RHETORIC SELF STORAGE

SITE DEVELOPMENT PLAN - MINOR AMENDMENT

LOT 1 STERLING RECYCLING SUBDIVISION, EL PASO COUNTY, STATE OF COLORADO
EPC PLAN NO. PPR2524

V1_Site Development Plan.pdf Markup Summary

A100

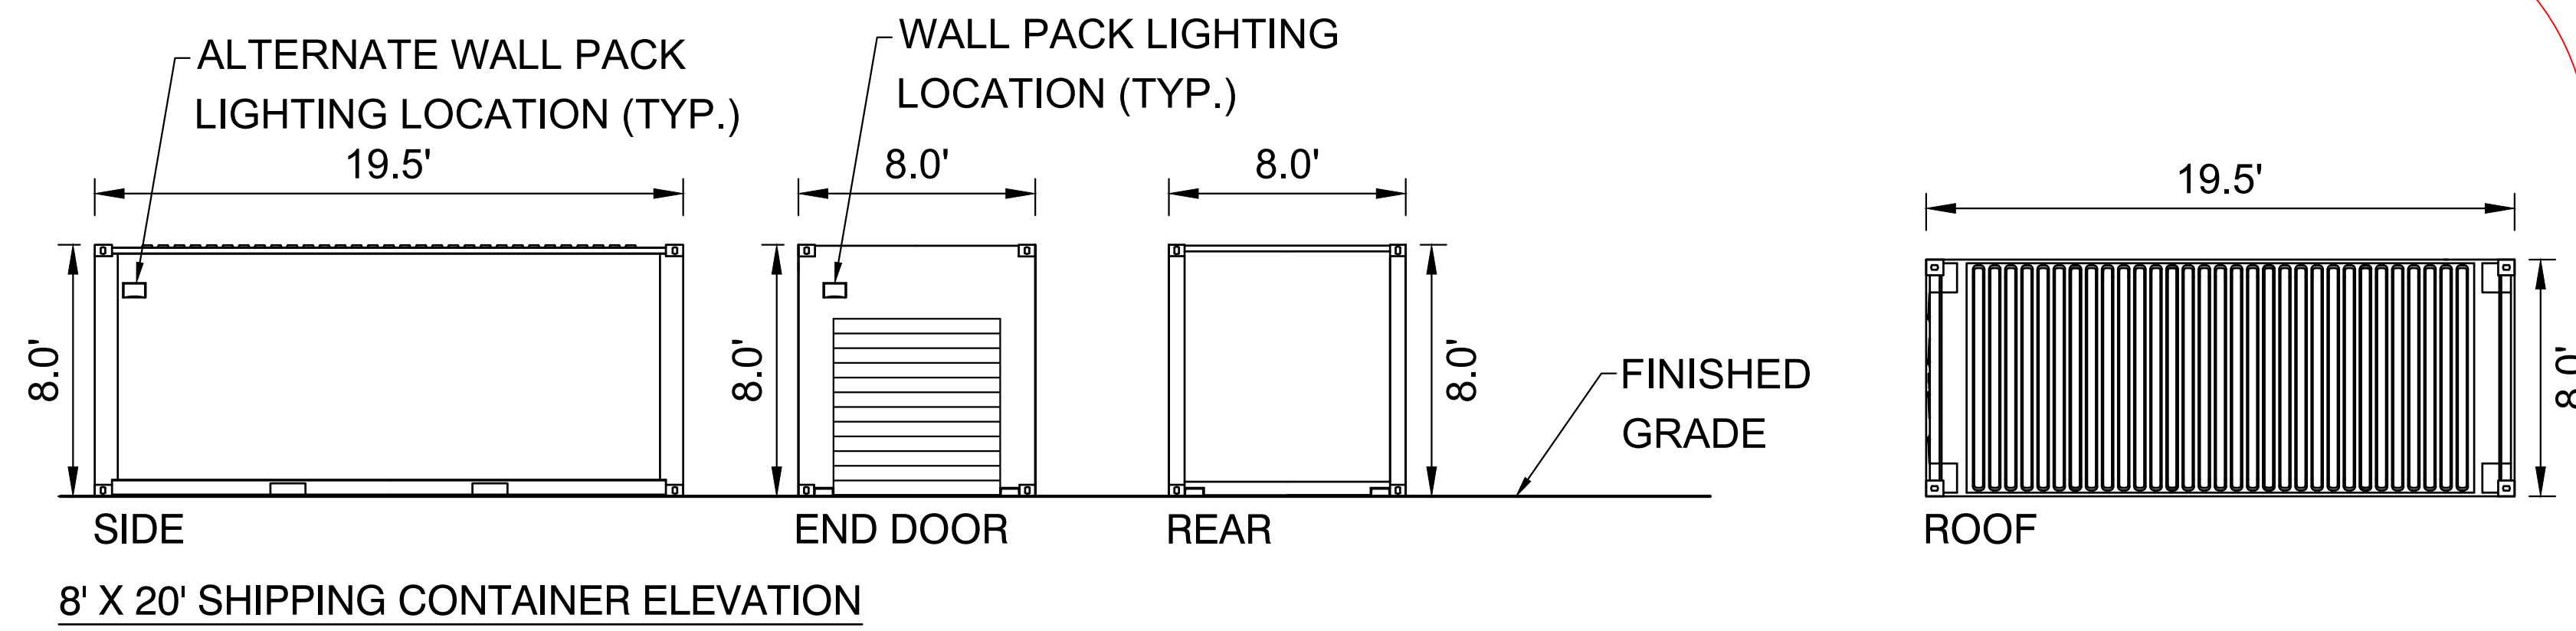
the elevations remove the 8 x 10 and 8 x 40 units all together and depict 8x 19.5' that indicates an increase in square footage

the elevations remove the 8 x 10 and 8 x 40 units all together and depict 8x 19.5' that indicates an increase in square footage

SP01

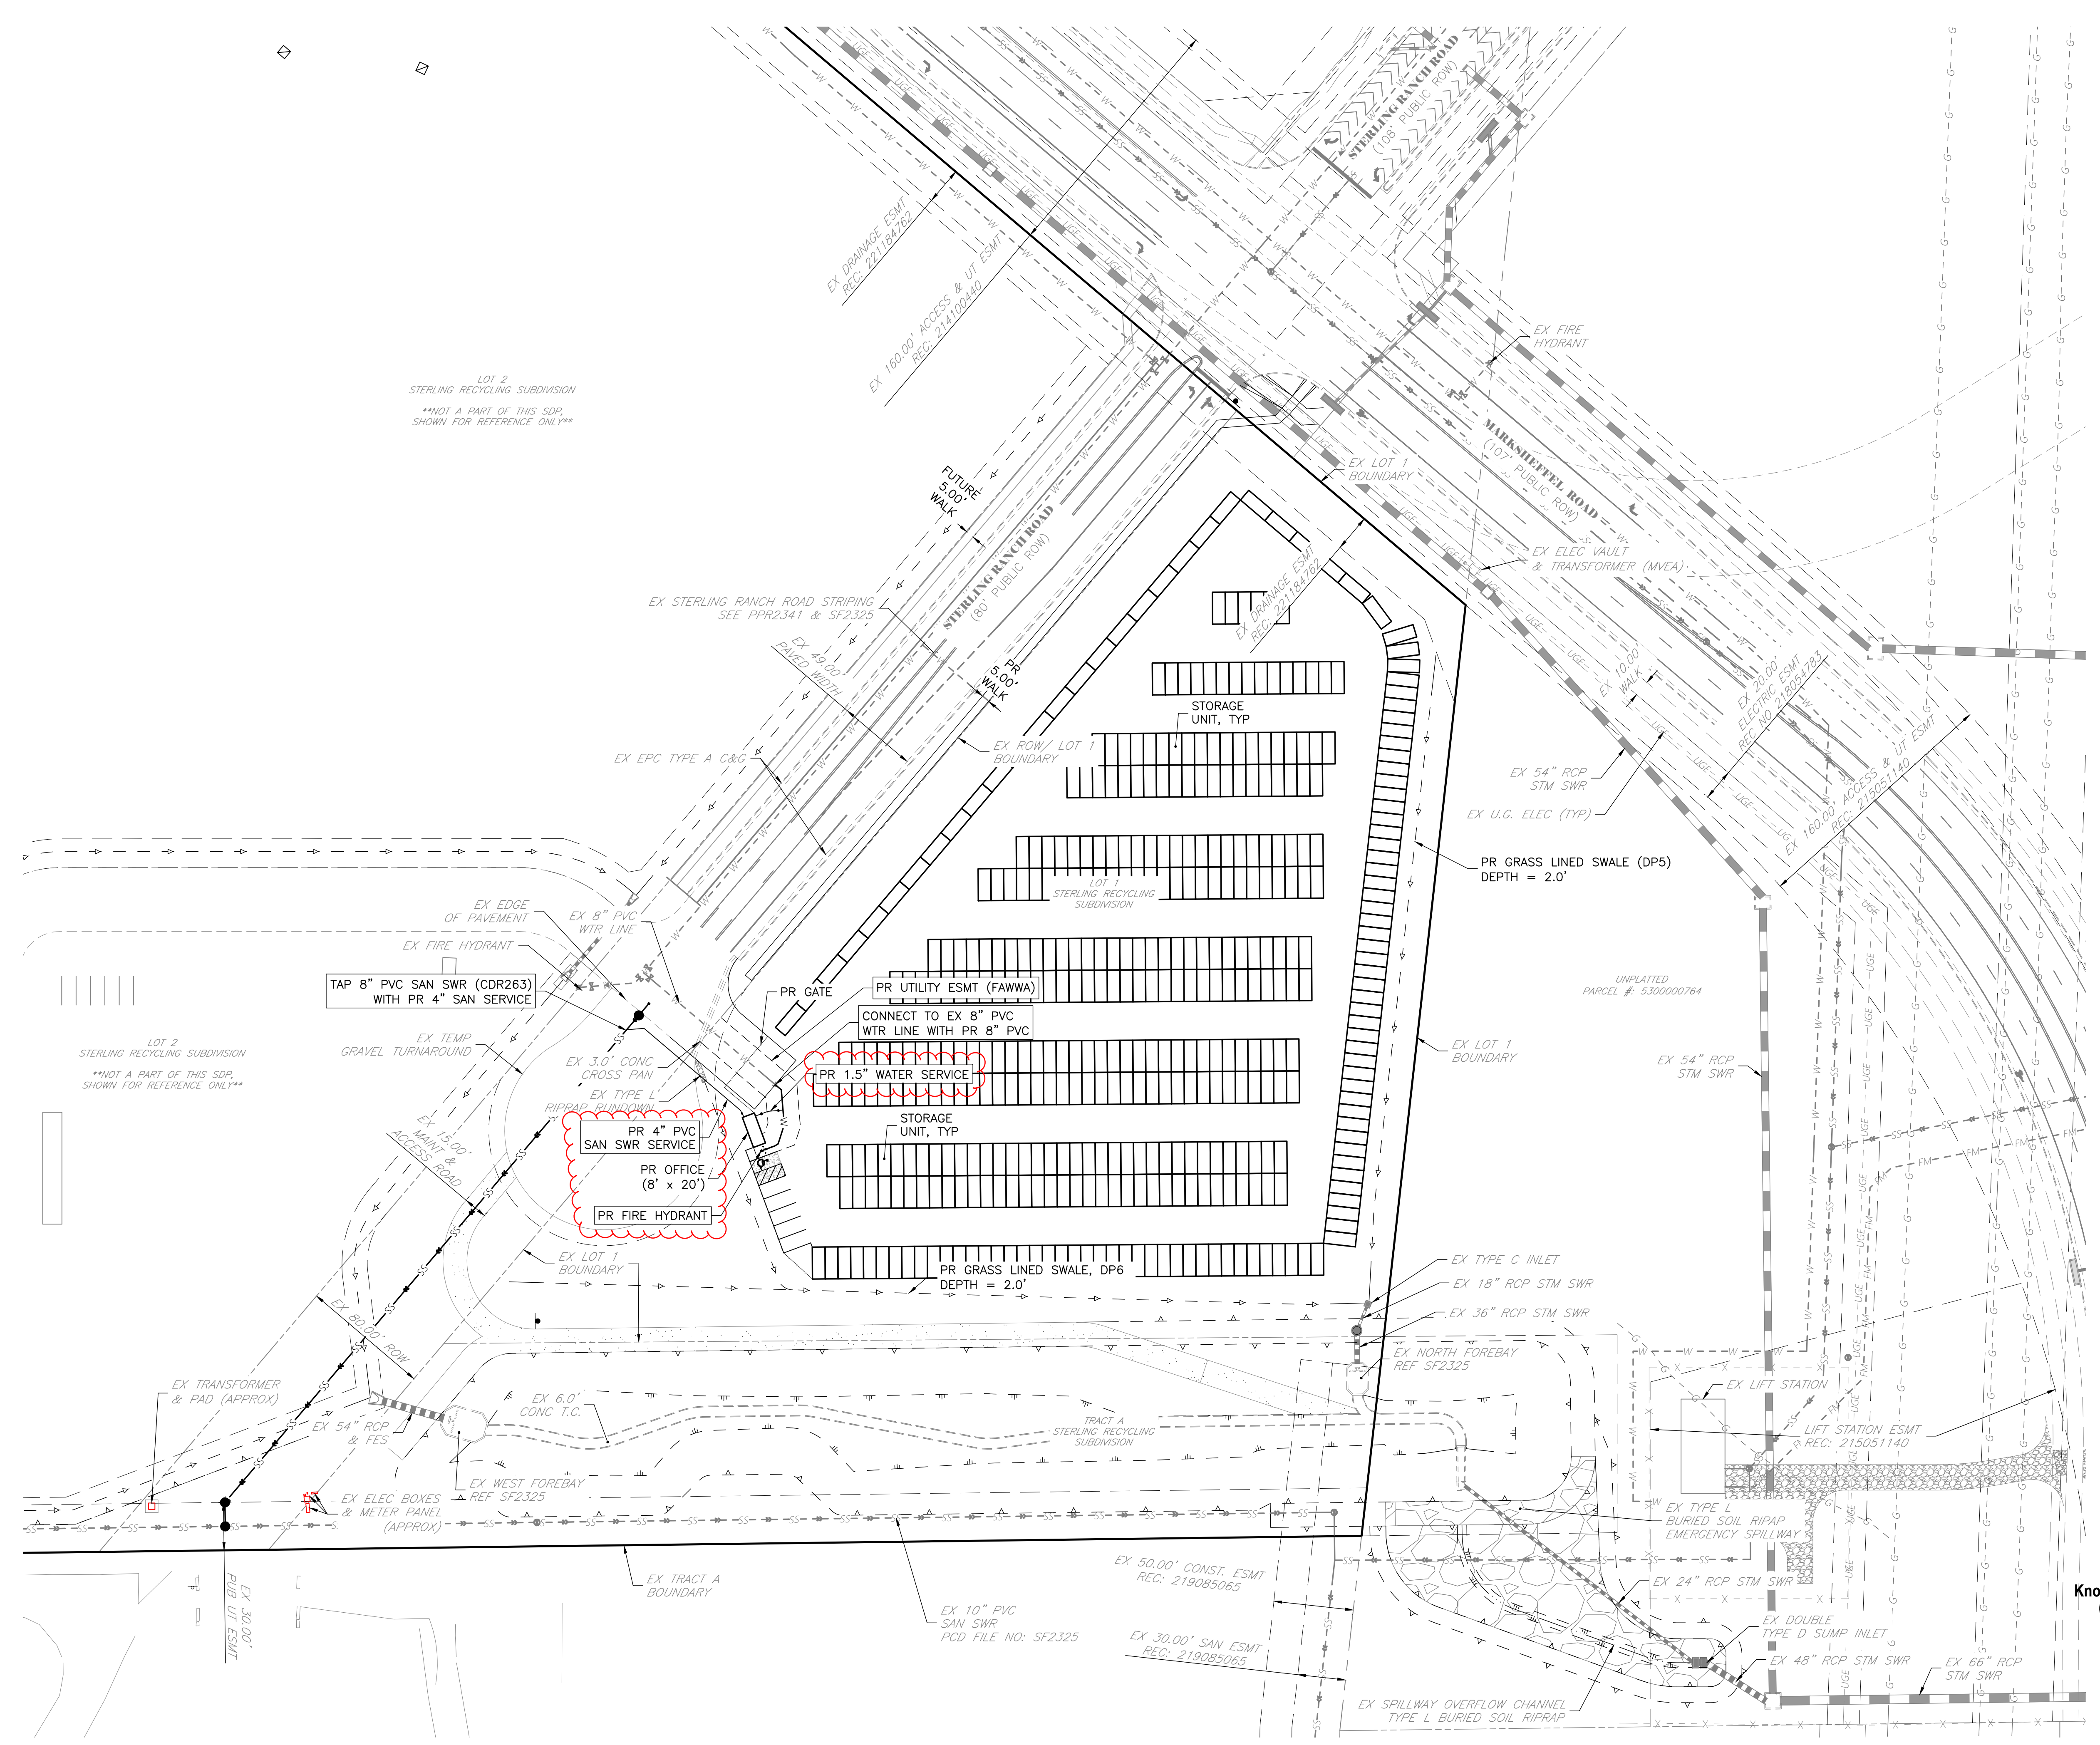
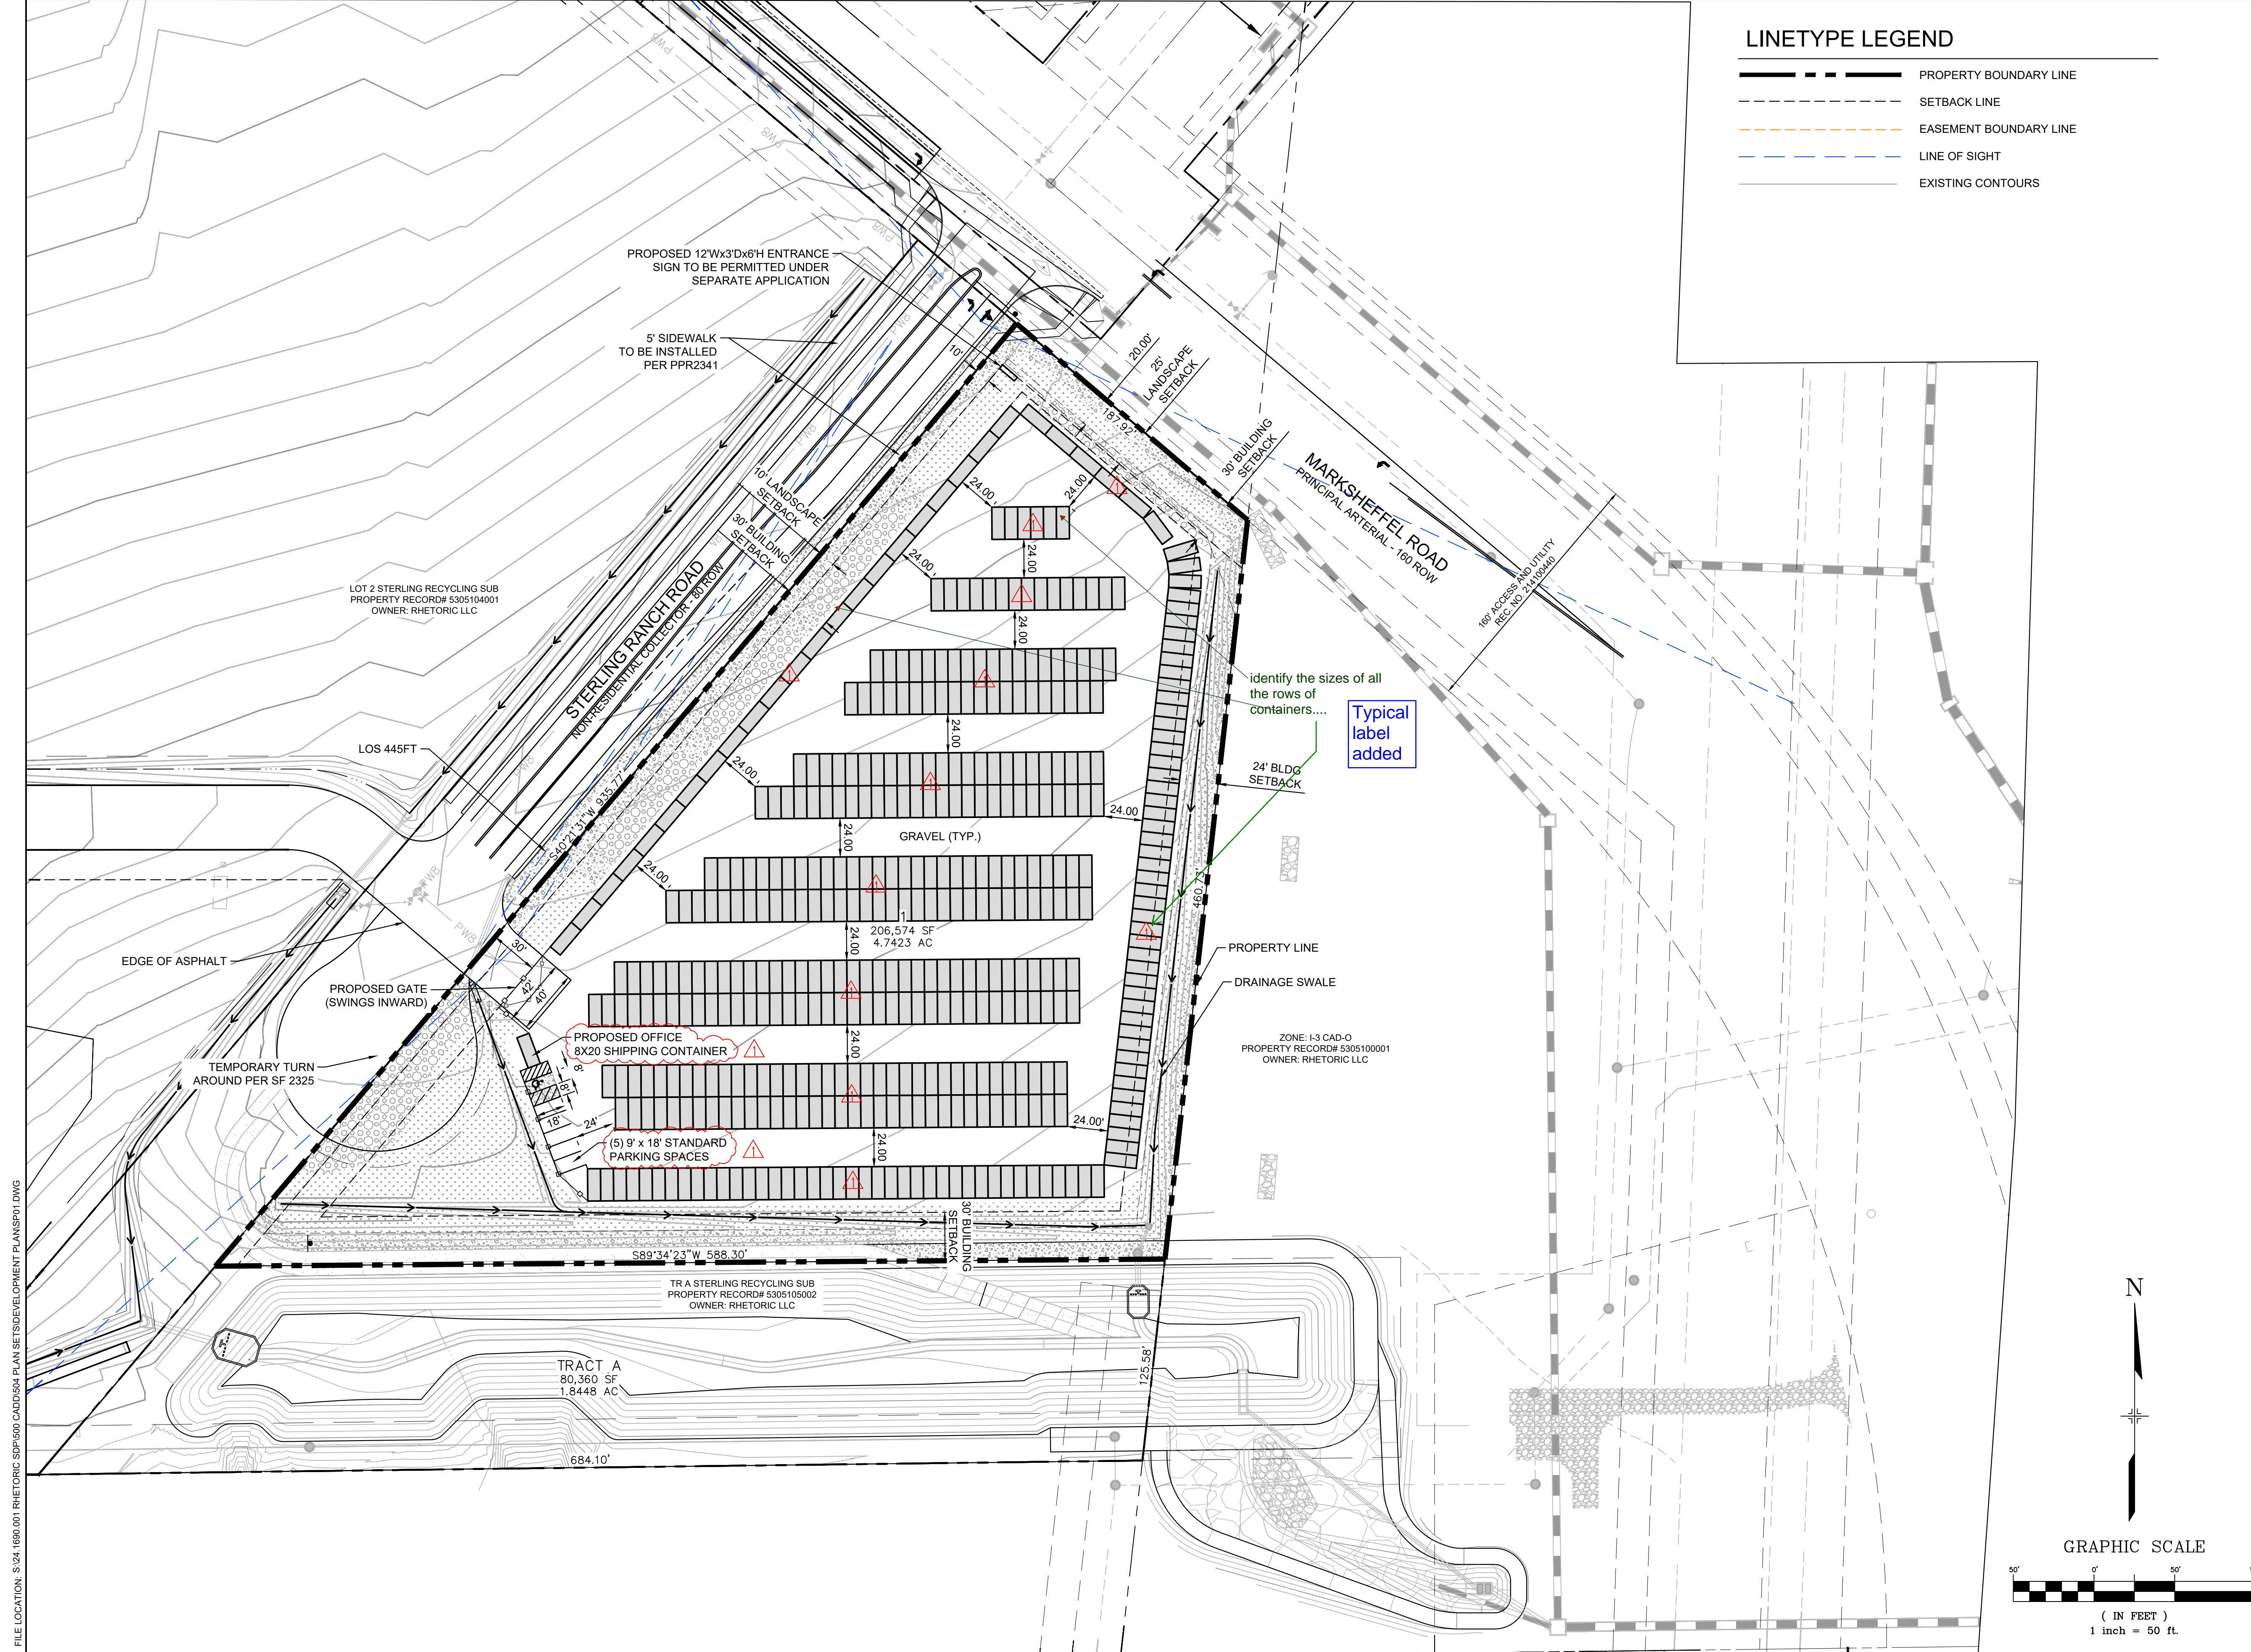
identify the sizes of all the rows of containers....
